Morgan and Morecambe Offshore Wind Farm: Transmission Assets

Appendix G3 to Natural England's Deadline 3 Submission
Natural England's further advice on Onshore Ecology and Nature Conservation

Planning Inspectorate Reference EN020028

07 July 2025

**Figure 1.6: Provisional ALC mapping within the study area (sheet 3)**

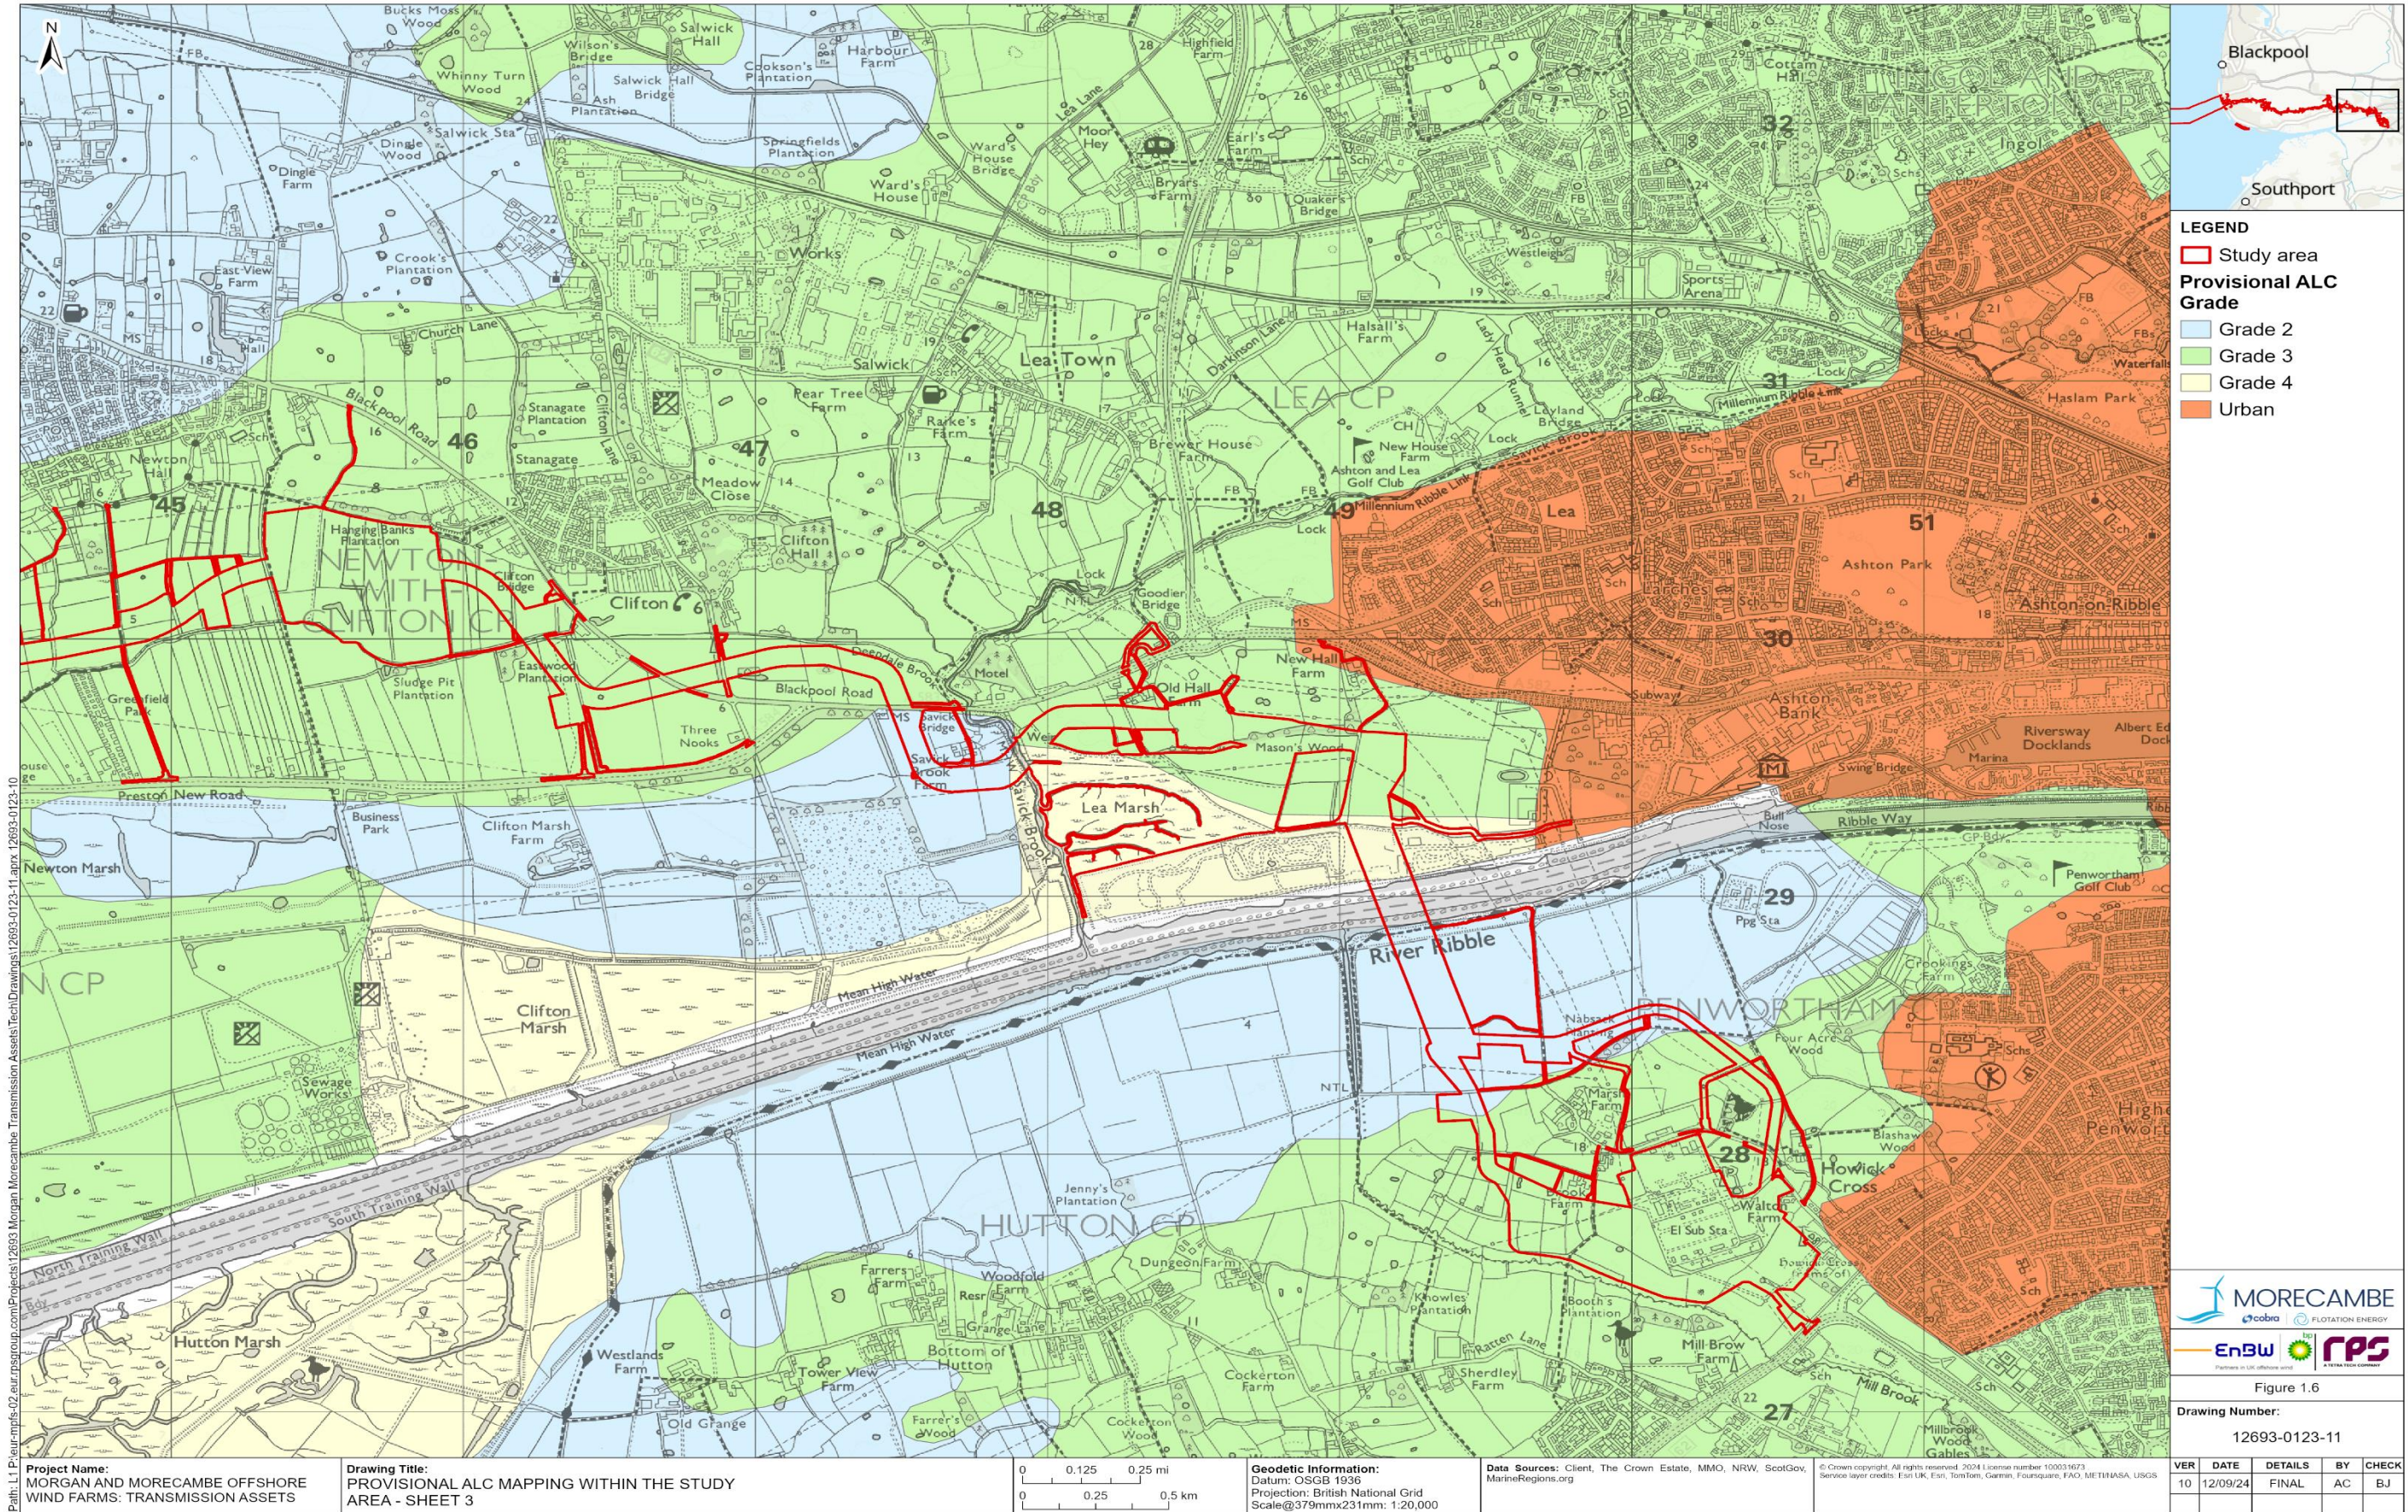
In the absence of a detailed, site-specific soil and Agricultural Land Classification (ALC) survey and assuming that all mapped ALC Grade 3 land are Best and Most Versatile (BMV) soils (i.e. Subgrade 3a), it is not possible to provide an accurate baseline and demonstrate the likely potential impacts. So, whilst any mitigation may be regarded as precautionary, it means that the Applicant is unable to show how it avoids impacts to BMV soils nor the design of potential mitigation to safeguard the soil resources.

The Environmental Statement (ES) should quantify the areas of land according to Grades 1 to 5 of the ALC, including differentiating between Grades 3a and 3b. While Natural England recognises the Applicant's acknowledgement of the deficiencies within the provisional dataset and that provisional mapping provides an indication of the ALC grade, and thus the potential impact on BMV agricultural land; it does not provide the soil details required to inform soil management which would feed into the Soil Management Plan. There is a risk of soil damage, ALC degradation and long term or permanent loss of BMV soils from cable installation. Soil will need to be handled according to best practice and reinstated to a high standard to reduce the impacts. The results from a detailed ALC survey would provide soils data to inform a soil management plan for the whole site regardless of whether the use is permanent or temporary in nature and provide the Secretary of State with the necessary comfort in the mitigation measures.

Natural England acknowledges the Applicant's effort to provide a conservative, worst-case assessment of agricultural land quality by applying the highest ALC grade within mixed soil types. However, in line with Paragraph 5.11.34 of the Overarching National Policy Statement for Energy (EN-1), it is essential that development proposals demonstrate how the use of Best and Most Versatile (BMV) land, Grades 1, 2, and 3a, has been avoided where possible, and that any unavoidable impacts are clearly justified and appropriately mitigated.

While the Applicant has presented ALC data and committed to further surveys prior to construction, Natural England remains concerned that the current assessment may not fully demonstrate how impacts to BMV land has been minimised across all elements of the

Transmission Assets. The reliance on a worst-case assumption, while precautionary, does not substitute for a spatially explicit breakdown of BMV land take by infrastructure component, nor does it confirm whether alternative routing or siting options were considered to reduce BMV land losses.

- Clearly demonstrate how the layout has sought to avoid BMV land;
- Provide a transparent breakdown of BMV land affected by each infrastructure element; and
- Ensures that the forthcoming detailed Soil Management Plan includes enforceable measures to protect and restore BMV soils during and after construction.
